# CITY OF ALBUQUERQUE

**Re: McDade-Woodcock Building, 2402 Claremont NE,  
Approval of Permanent Certificate of Occupancy (C.O.)  
Engineer's Stamp dated 3/29/09 (H16/D142)  
Certification dated 7-24-09**

Re: Certification Submittal for Final Building Certificate of Occupancy for  
McDade-Woodcock Warehouse, [H-16 / D142]  
2322 Claremont Ave NE  
Architect's Stamp Dated 05/14/09

RE: **McDade-Woodcock Building, 2402 Claremont NE (MAP H16- D 142)**  
**Grading & Drainage Plan for Building Permit and SO-19 - PE Stamp 01-08-09**

McDade-Woodcock Building
GRADING & DRAINAGE PLAN

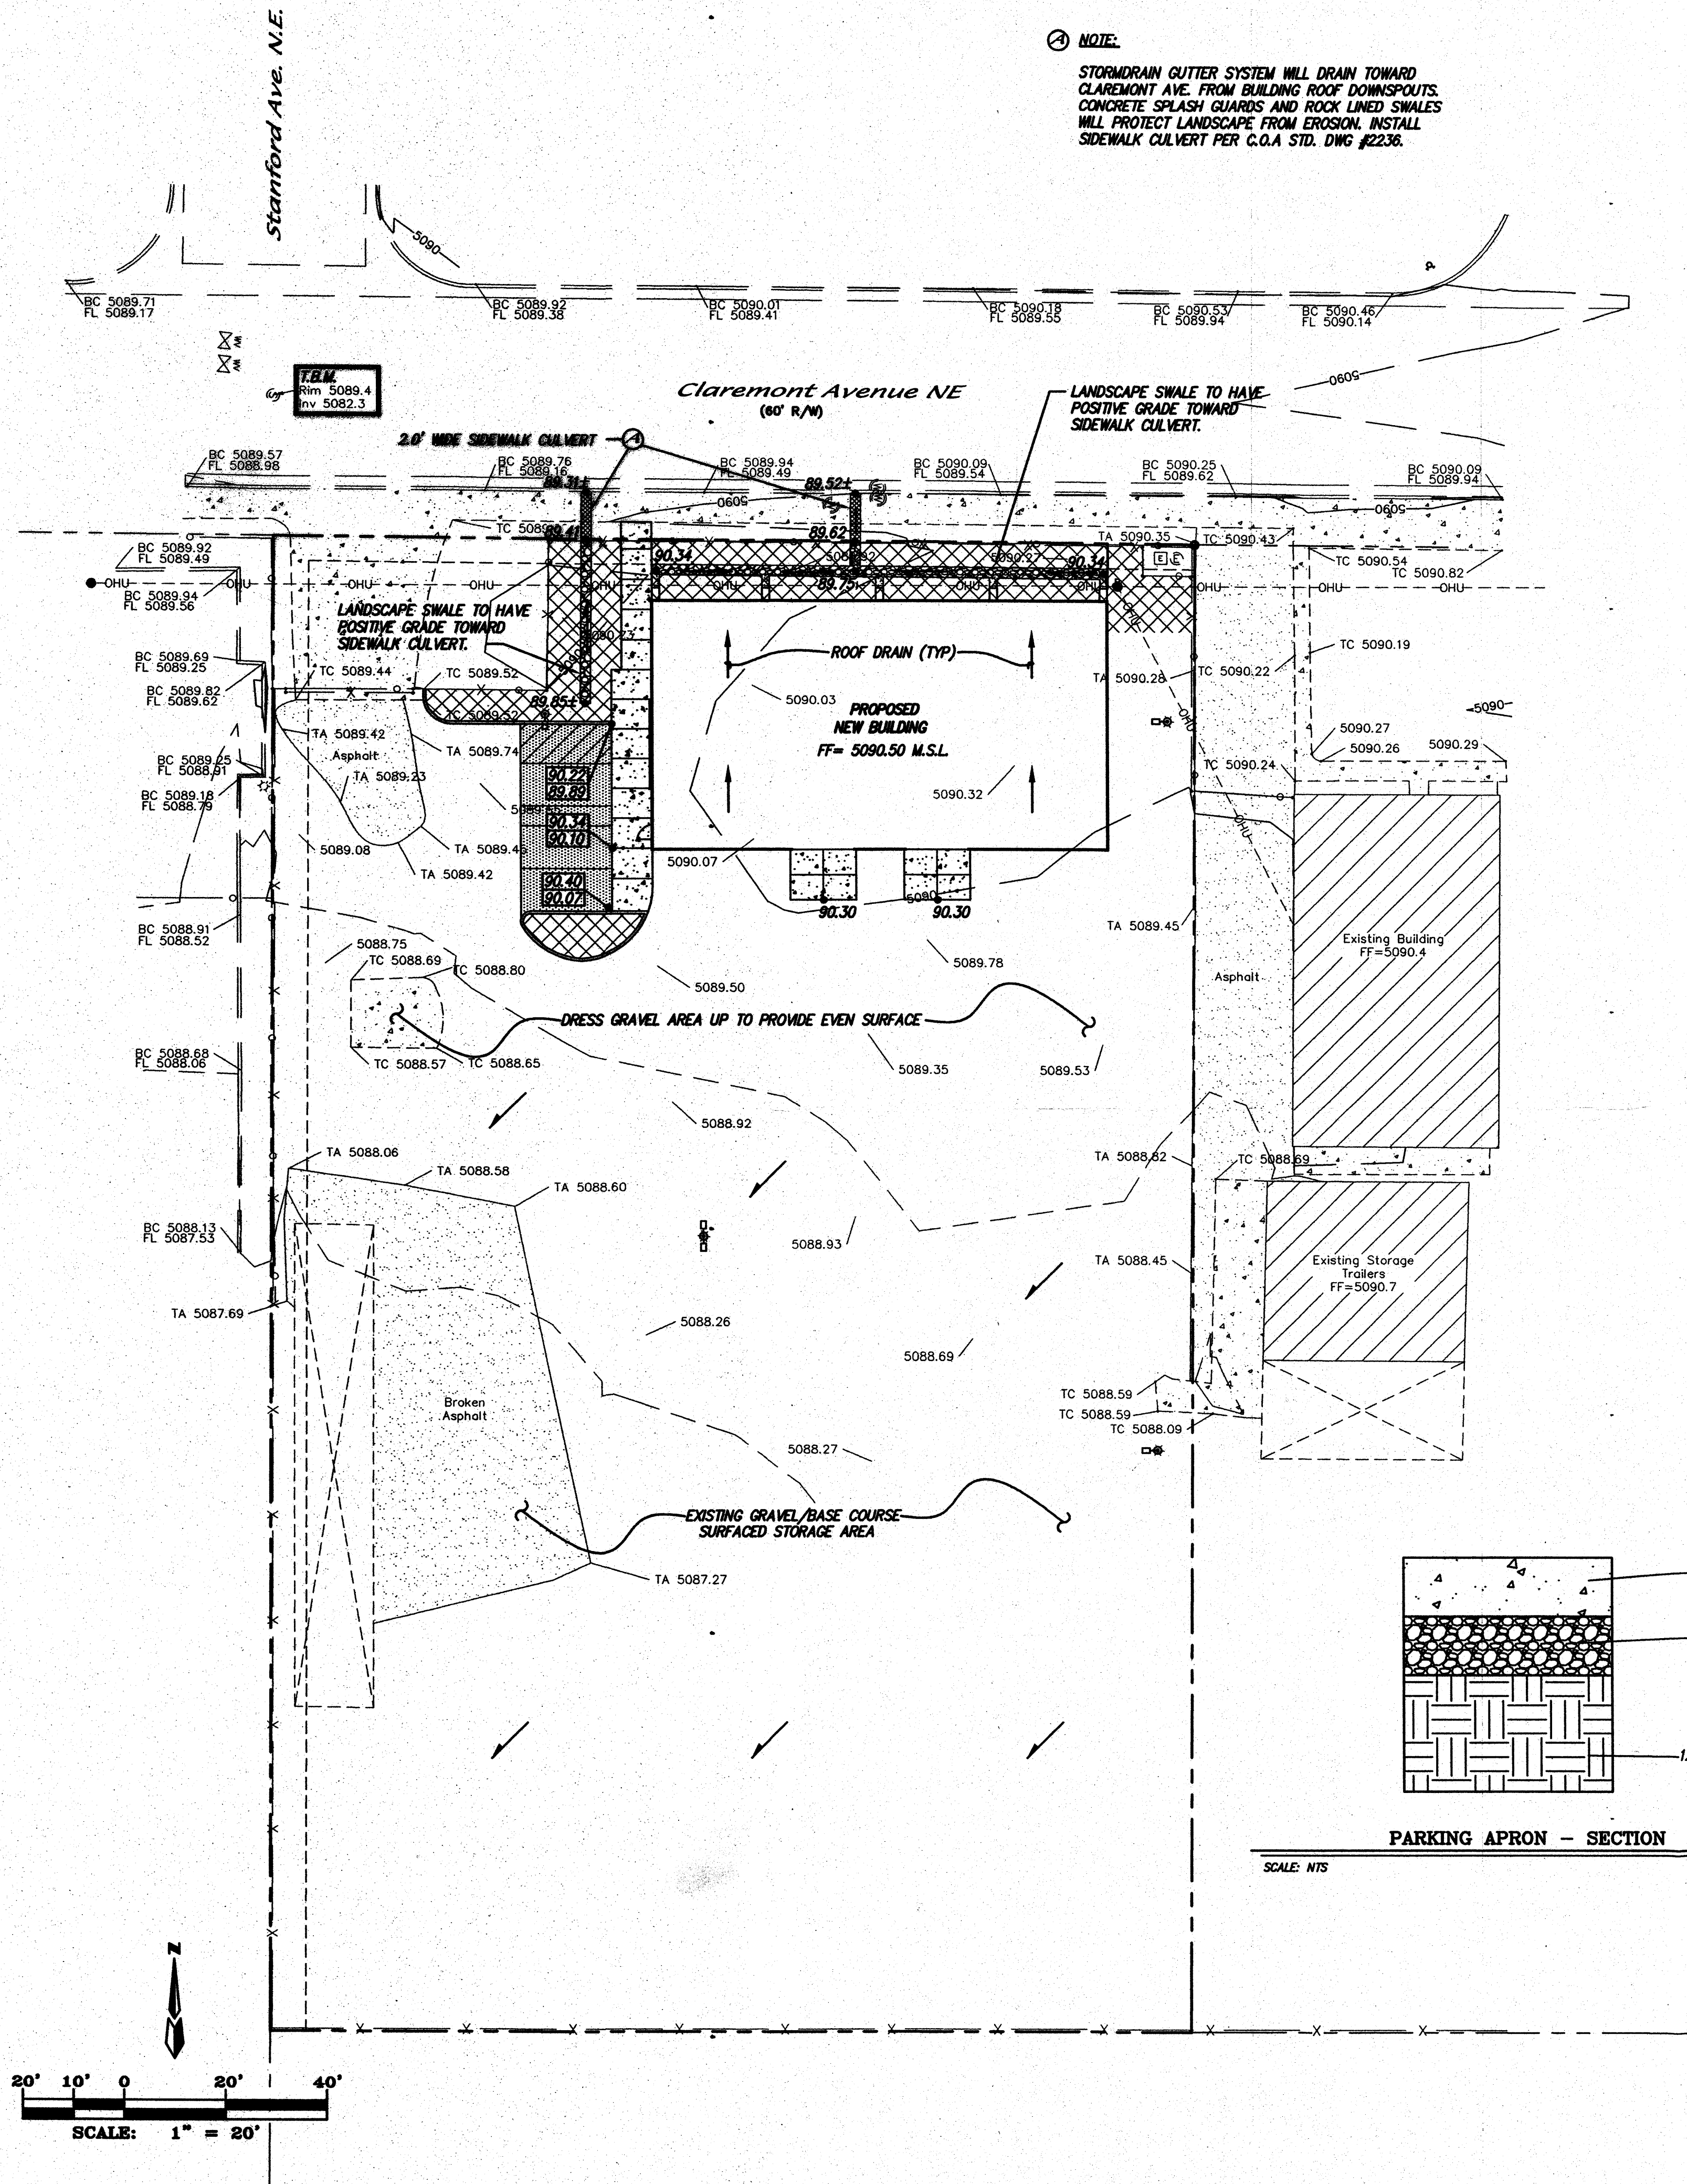
1. Clarify on the maps and narrative that the street to the south, where site flows are draining, is Phoenix, not Princeton.
2. The Grading and Drainage Plan must reference the applicable FIRM map which indicates that no Flood Zone overlays the site.

3. Proposed improvements are increasing site discharge by more than 10%. Downstream conditions and possible improvements must be included in this plan to ensure that flows remain in established drainage ways and do not increase erosion.

4. If both this site and the downstream property are owned by the developer, it would be appropriate at this time to dedicate downstream drainage easement rights.

5. An alternative to dealing with downstream conditions would be to divert enough of the developed flows north to Claremont Street, and avoid increasing the flow rate to the private property south. (e.g.- Divert new building roof runoff through a sidewalk culvert on Claremont)

This is the updated Grading and Drainage Plan which addresses your comments. We have extended the sidewalk culverts to the property line north of the proposed building and set elevations for the drainage swales. Attached to this letter are two copies of the grading and drainage plan.

A001
OF

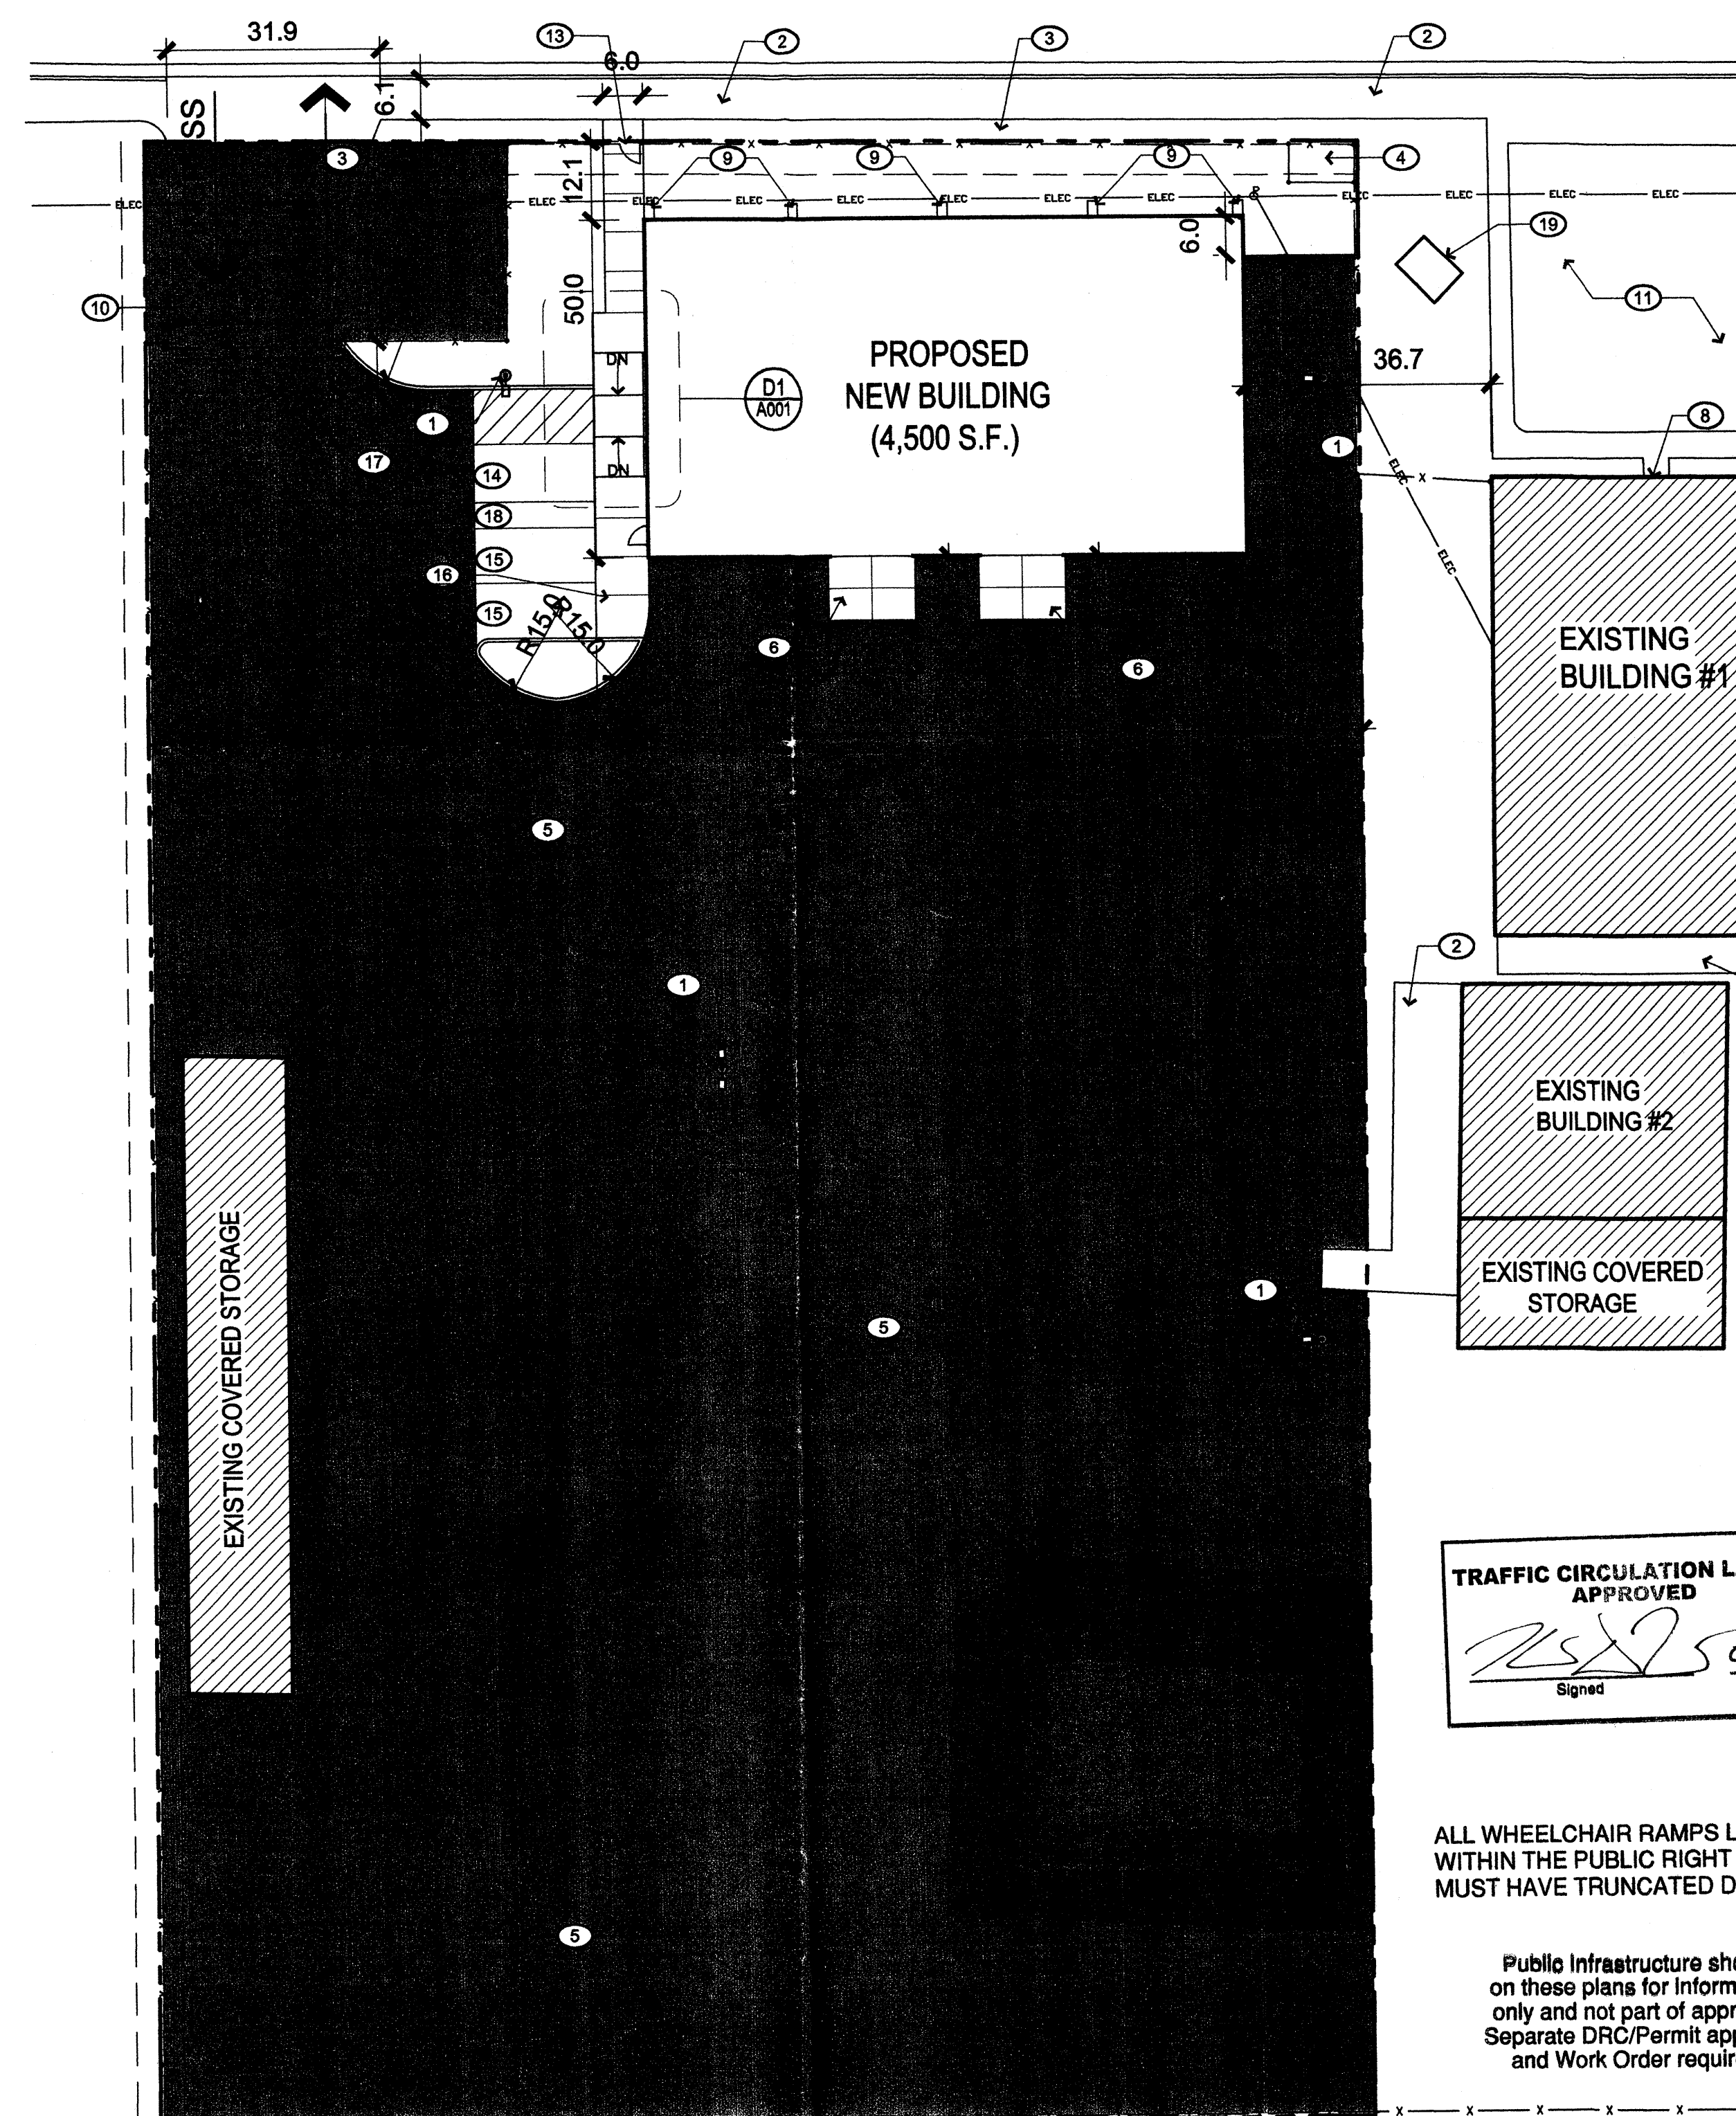
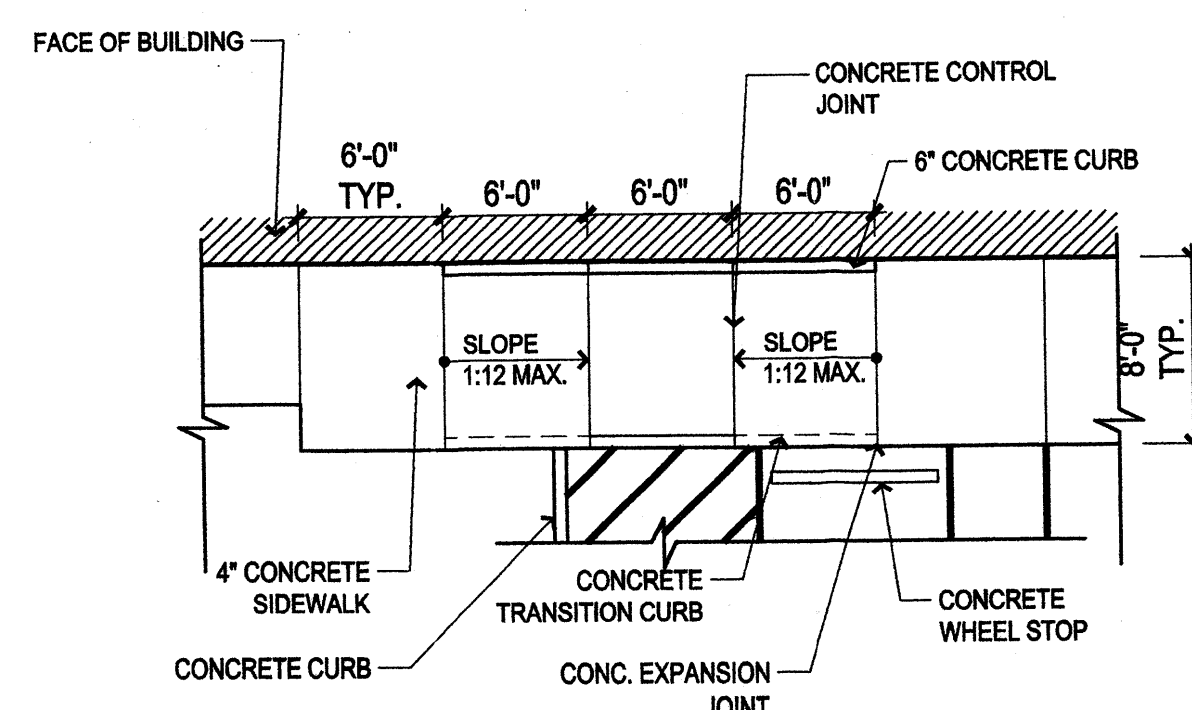
- ~~1. List~~ radii for all curves shown; for passenger vehicles, the minimum end island radius is 15 feet.
- ~~2. Clarify~~ existing versus proposed conditions.

- ~~3. The~~ pedestrian connection to Claremont Avenue must be built at this time, not at a later date. A pedestrian gate (a minimum of 3 feet in width) must be added to the existing fence.

- ~~4. Please~~ list the width and length for all parking spaces.
- ~~5. List~~ the number of parking spaces required by the zoning code as well as the proposed number of parking spaces.

- ~~6. Call~~ out the width of all sidewalk, both existing and proposed.
- ~~7. Provide~~ a detail for the proposed wheelchair ramp; define the maximum slope.

8. Clearly indicate the location of the handicapped parking space. Please note that the handicapped parking space and the van access aisle (8 feet wide minimum) must be hardlined.

- ~~9. List~~ the width of the existing drivepad.
10. Please include a copy of your shared access agreement with the adjacent property owner.
